Demolition of existing garage & outbuildings. Alterations to external materials (including change from thatch to clay tiled roof and brick/stone to fibre cement weatherboarding and coloured render). Alterations to existing fenestration, including to 2 no. ground floor rear bay windows, and addition of first floor front dormer, enlarged balcony at first floor level at the rear. Replacement garages.

The Breakers 29 Tamarisk Way East Preston

Thank you for your internet representation made on 25th January 2020 which has been recorded as '**an objection**' with the comments as follows:

1:100 Roof Plan

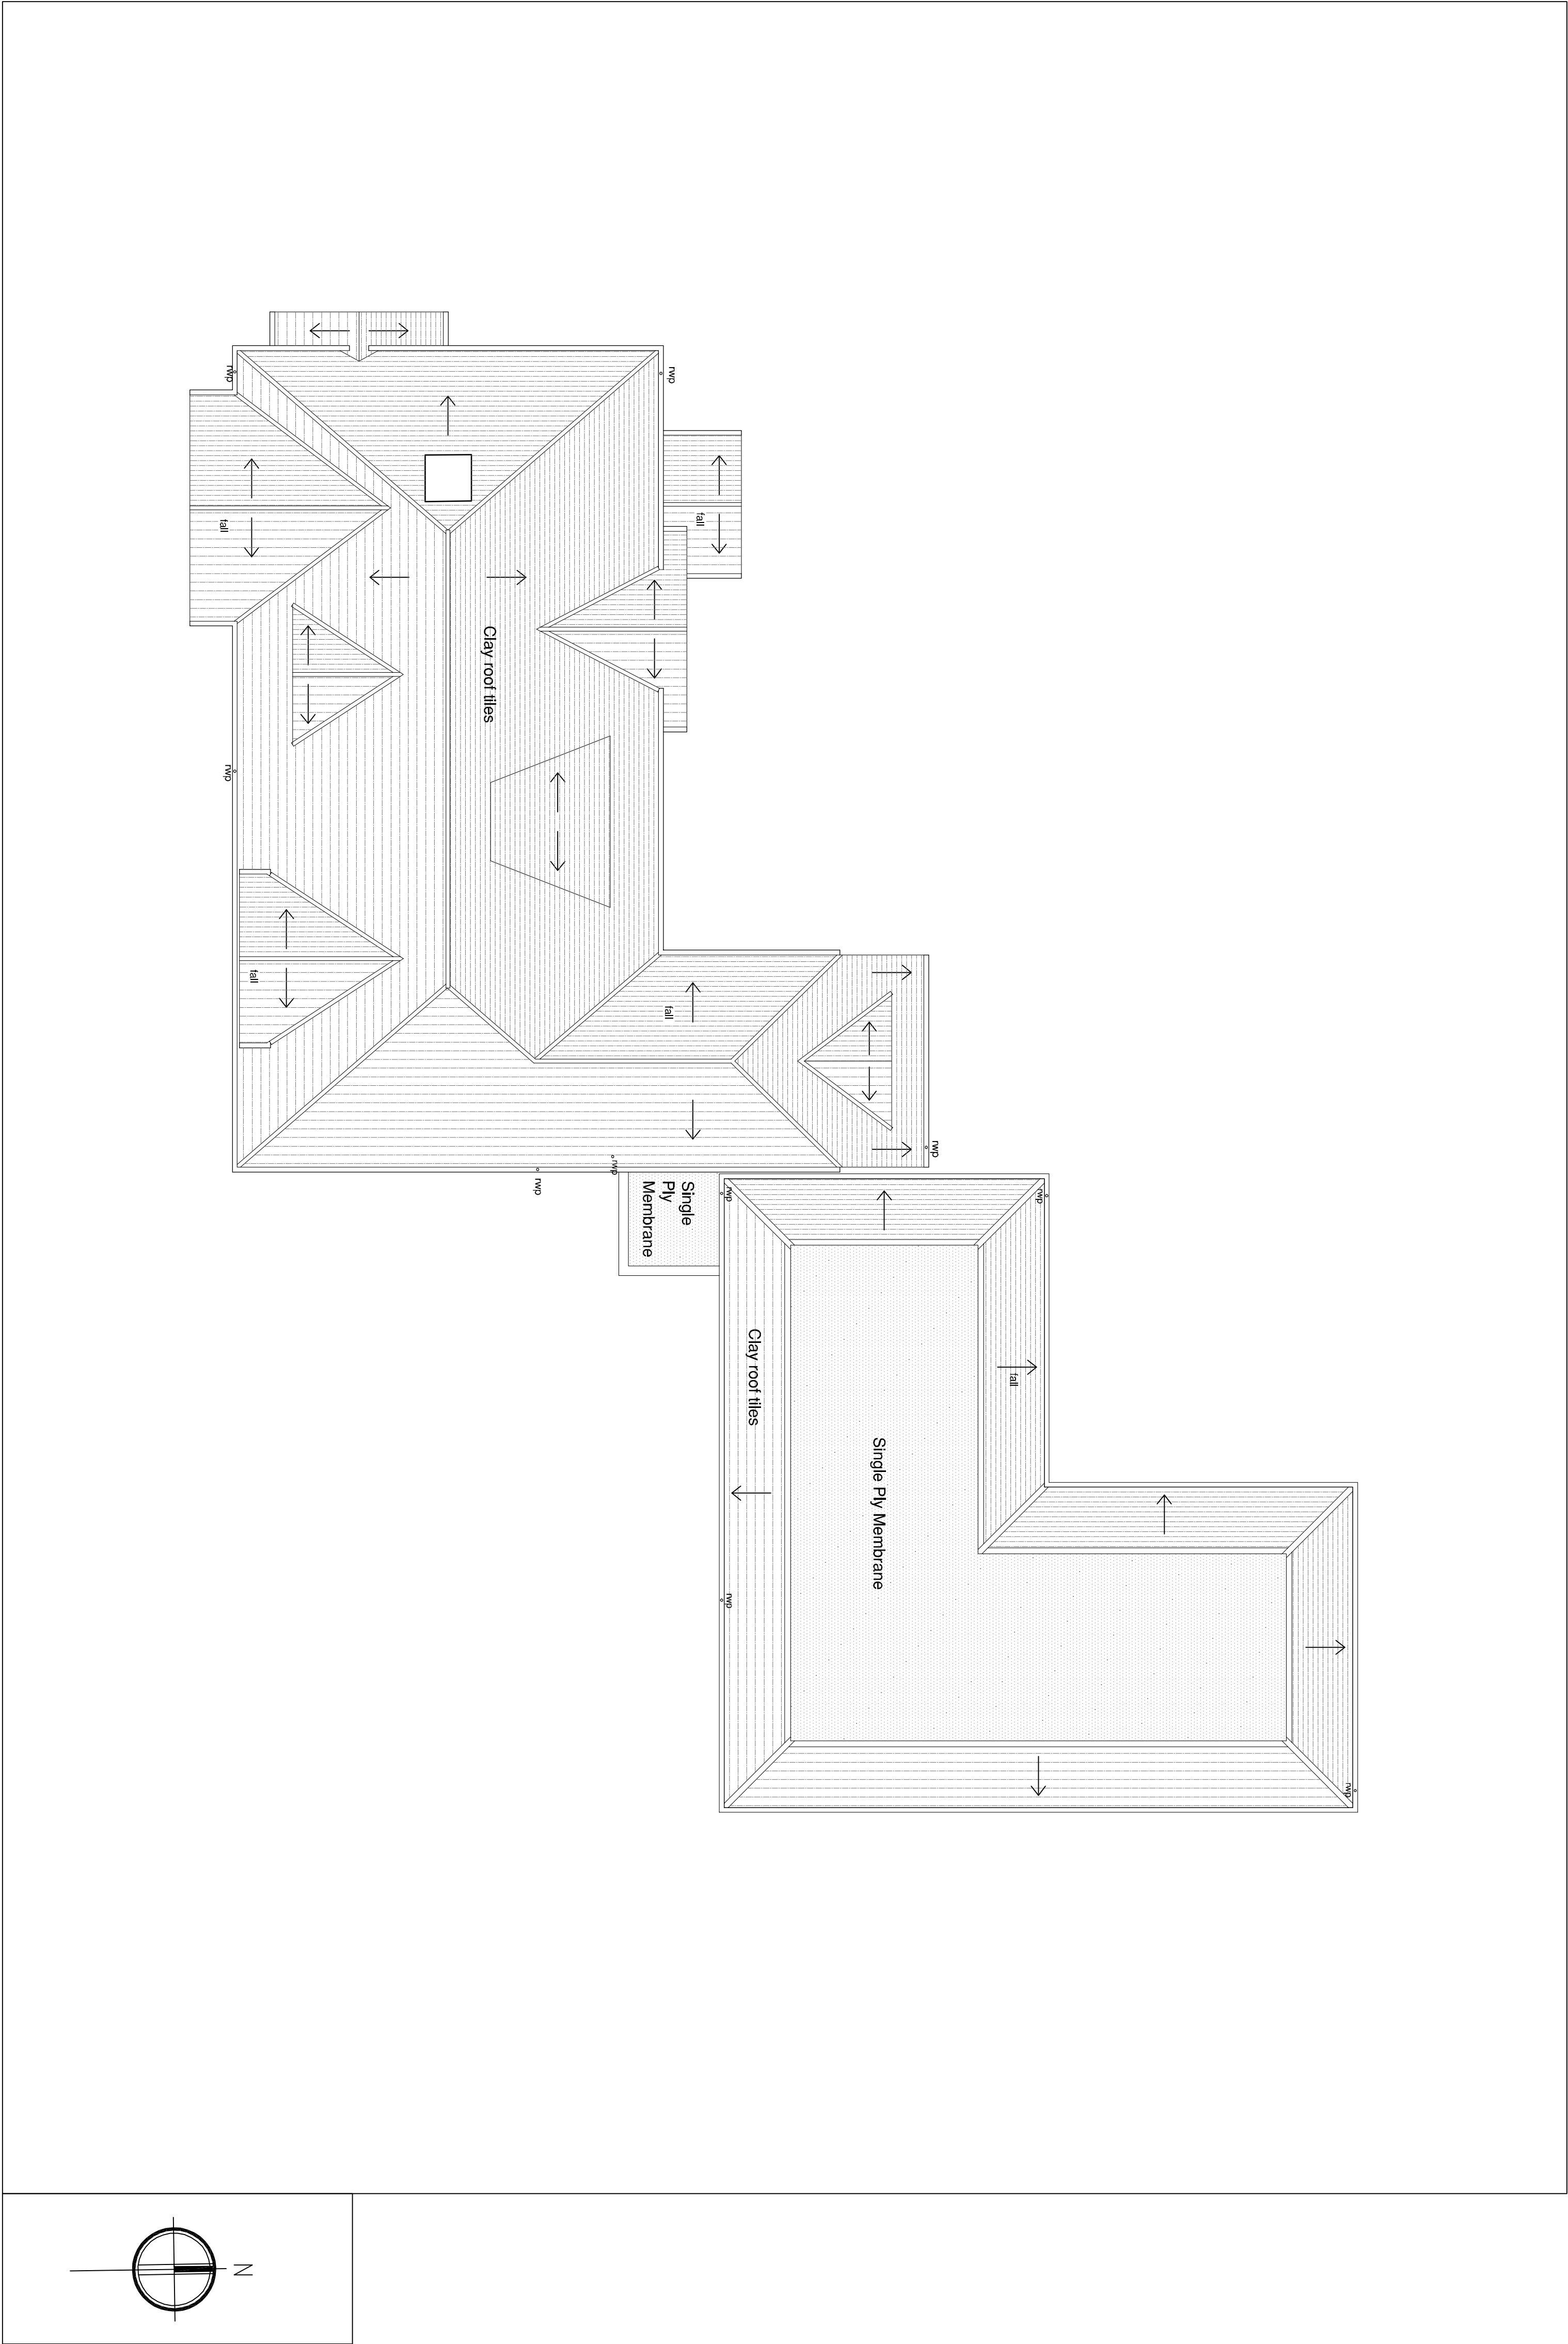
*Para. 4.1 claims the removal of the thatch and two chimneys would reduce the "overbearing appearance of the property". The property is far from overbearing as it stands on its own large plot and is well separated from adjacent properties so that it is not overbearing.*
